| Application Ref: | 3/2025/0656 | | |  Ribble Valley Borough Council www.ribblevalley.gov.uk | | | | |
| DELEGATED ITEM FILE REPORT: | | | | | Decision | REFUSED | | |

| Development Description: | Prior Notification for proposed roofing over existing slurry/manure storage areas and proposed produce and machinery store under Part 6 Class A of the GDPO. |
| Site Address/Location: | Crane Wood Farm, Whitewell Road, Cow Ark, Whitewell, BB7 3DG |

# Drawing 3.0 - Elevation Plans

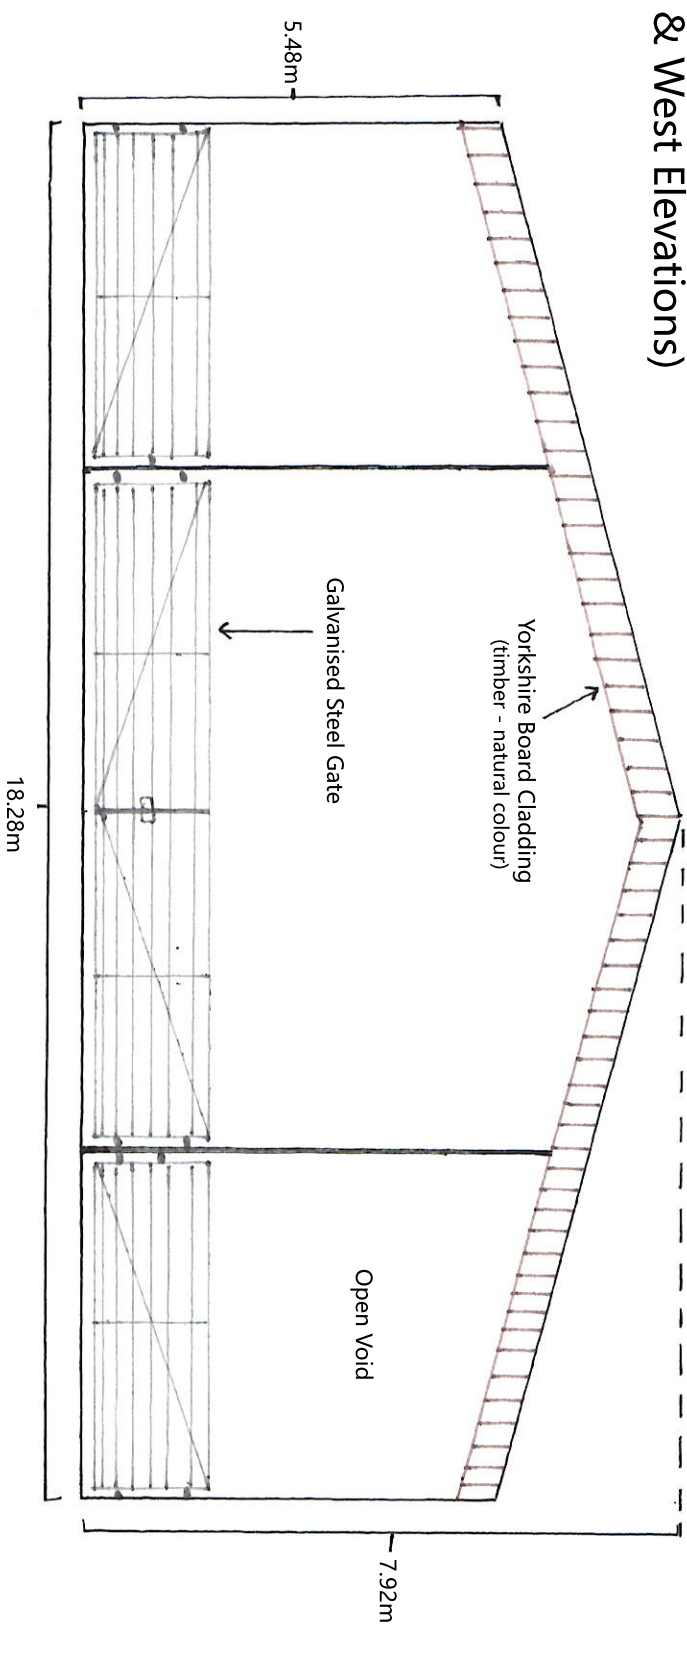
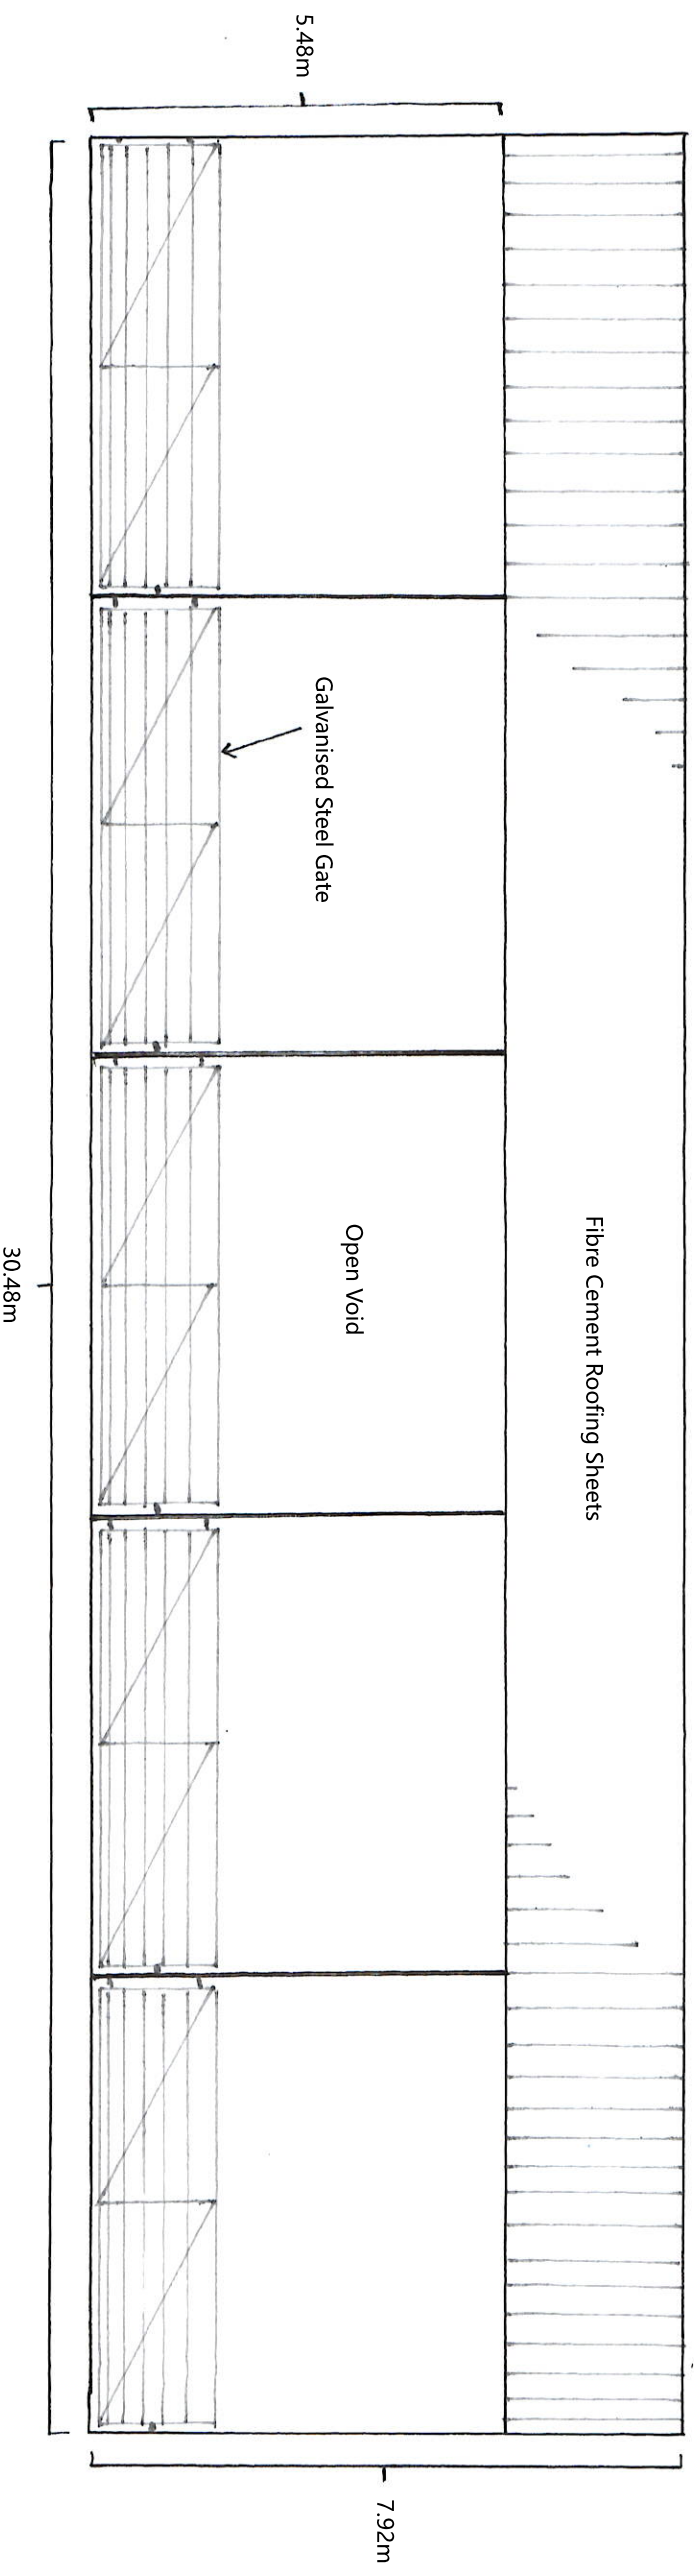
The proposed building would have a maximum height of 5.3 metres to the ridge.

Design / appearance – The proposed building is to be constructed using a fibre cement roofing, with Yorkshire board cladding to the upper part of the gable and galvanised steel gates to the perimeter of the building. As such, the appearance of the building would be mostly open.

The proposal would therefore not read as an incongruous or anomalous addition to the surrounding landscape. The proposal would also utilise traditional agricultural materials which are considered appropriate in character within the Forest of Bowland National Landscape.

Drawing 4.0 - Site/Block Plan

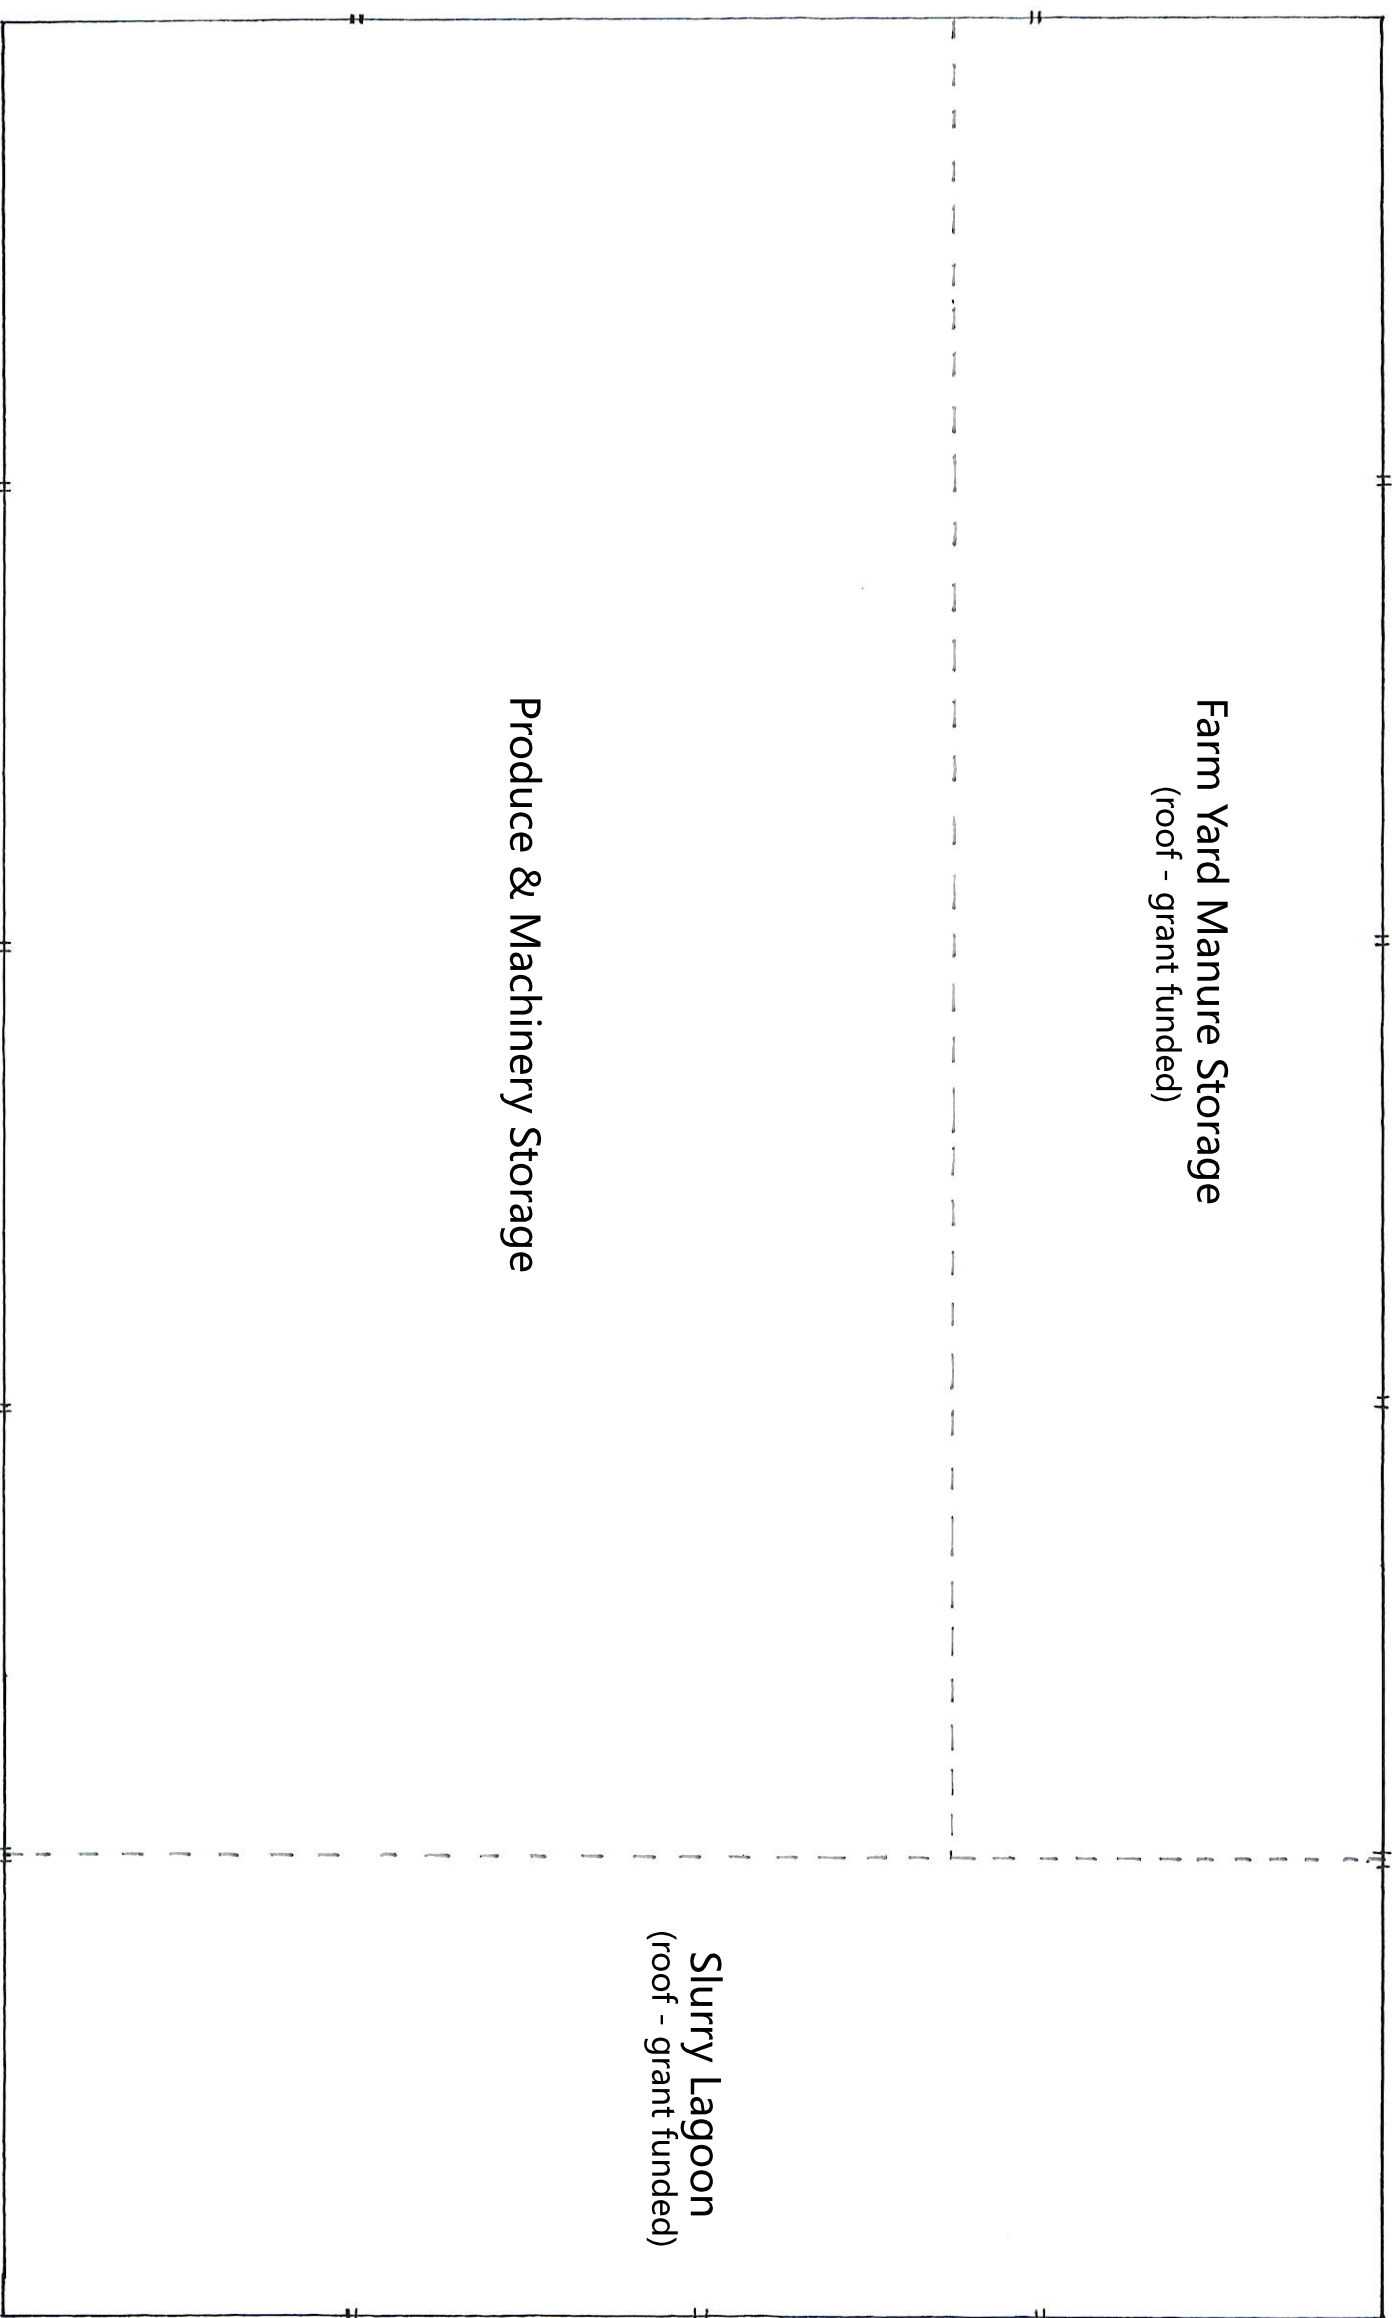
The proposed building is within 400 metres of a protected building (residential properties known as Smithy Cottage, Sugar Hill Lodge and Sugar Hill Farm) and would involve works to a building used/to be used for the storage of slurry as the roof covering would house the existing slurry tank.

Siting – The proposed building is to be located on a parcel of land that is covered by an existing structure. As such, the applicant would be required to demolish the structure in order to implement the development. The agricultural building would be fairly large in size, being 30.48m in length and 18.28m in depth and would be greater in footprint than the existing building as it would now include the covered area for the manure store and slurry store. However, the building would be open sided which would help to reduce its bulk and mass. As such, it is not considered that the development would result in harm to the landscape character within the Forest of Bowland National Landscape.
